From: Parish Clerk Billington and Langho Parish Council
<parishclerk@billingtonlanghopc.org>
Sent: 12 November 2025 12:24
To: Planning
Subject: 3/2025/0880

Following consultation with all members of the parish council the following objection and concerns have been raised.

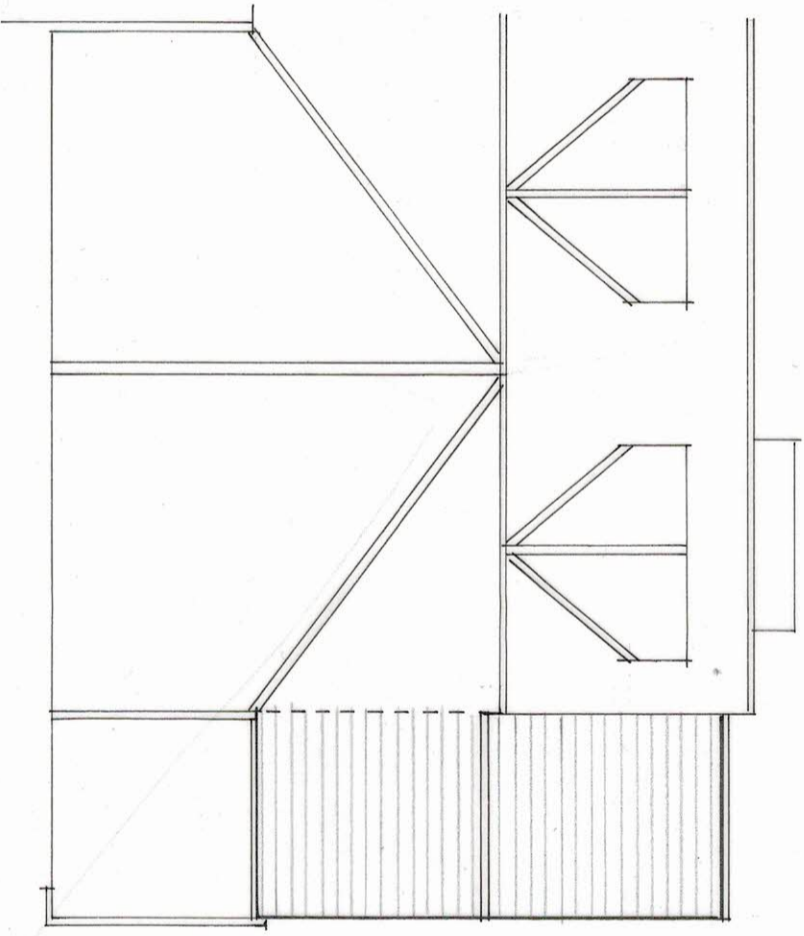
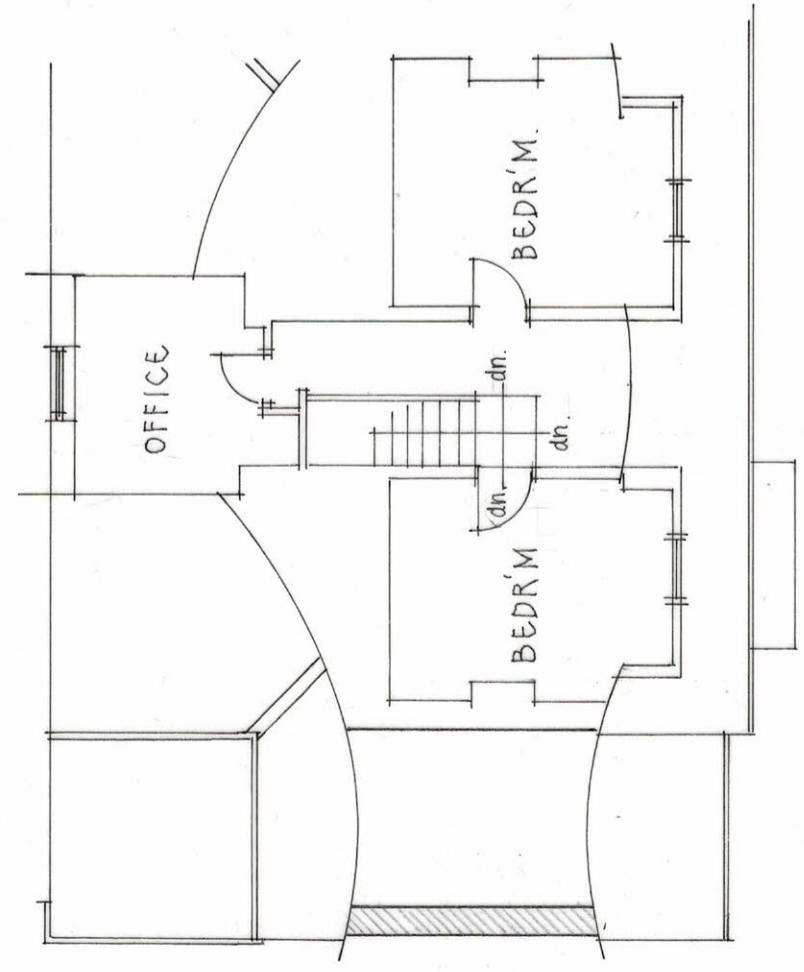
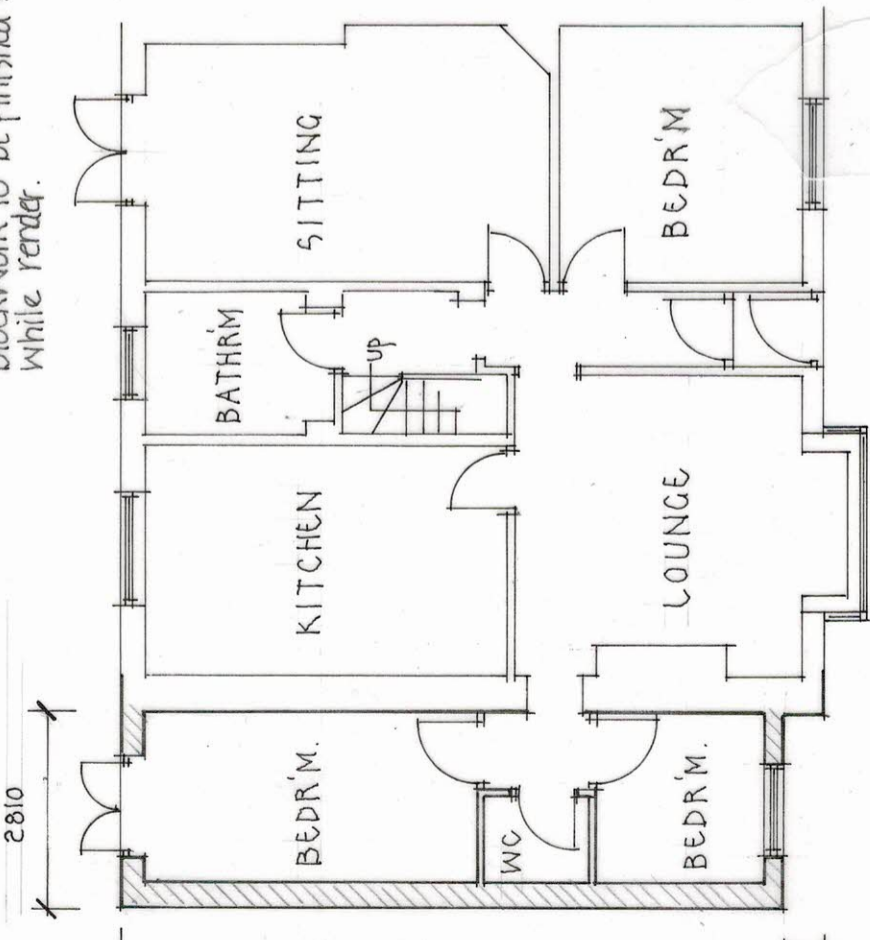
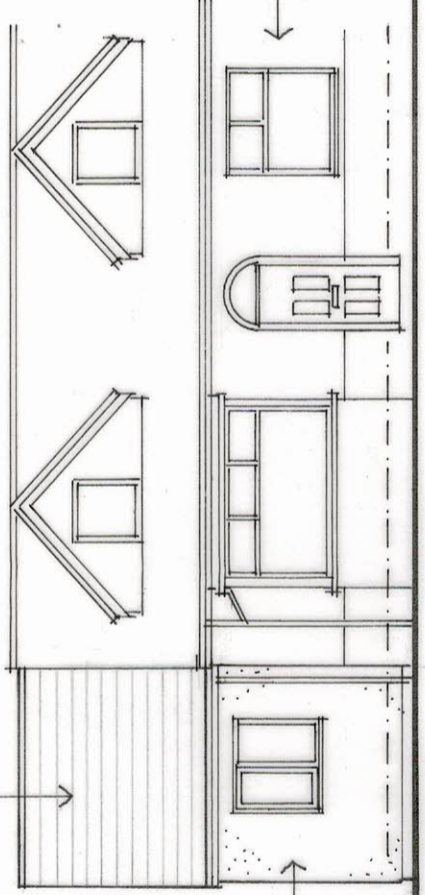
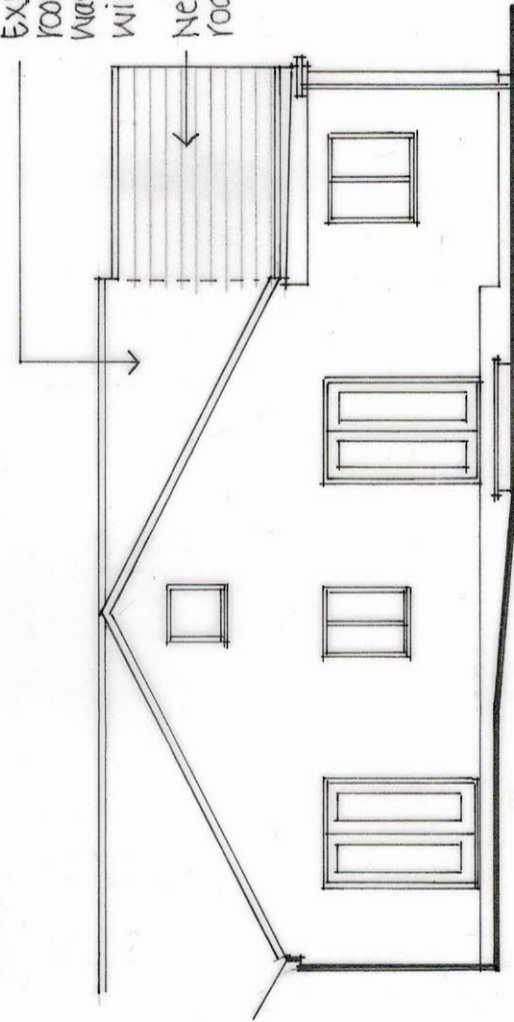
- Since the last application into planning the homeowners have replaced the flat roof with a pitched one to give it a more sympathetic look and added what must be a 8ft high fence on Springdale road (also in contravention with the usual 6ft permitted height) to try and mask the development.
- Our objections is that both the extention and the fence show blatant disregard for planning consents and the neighbours close by.
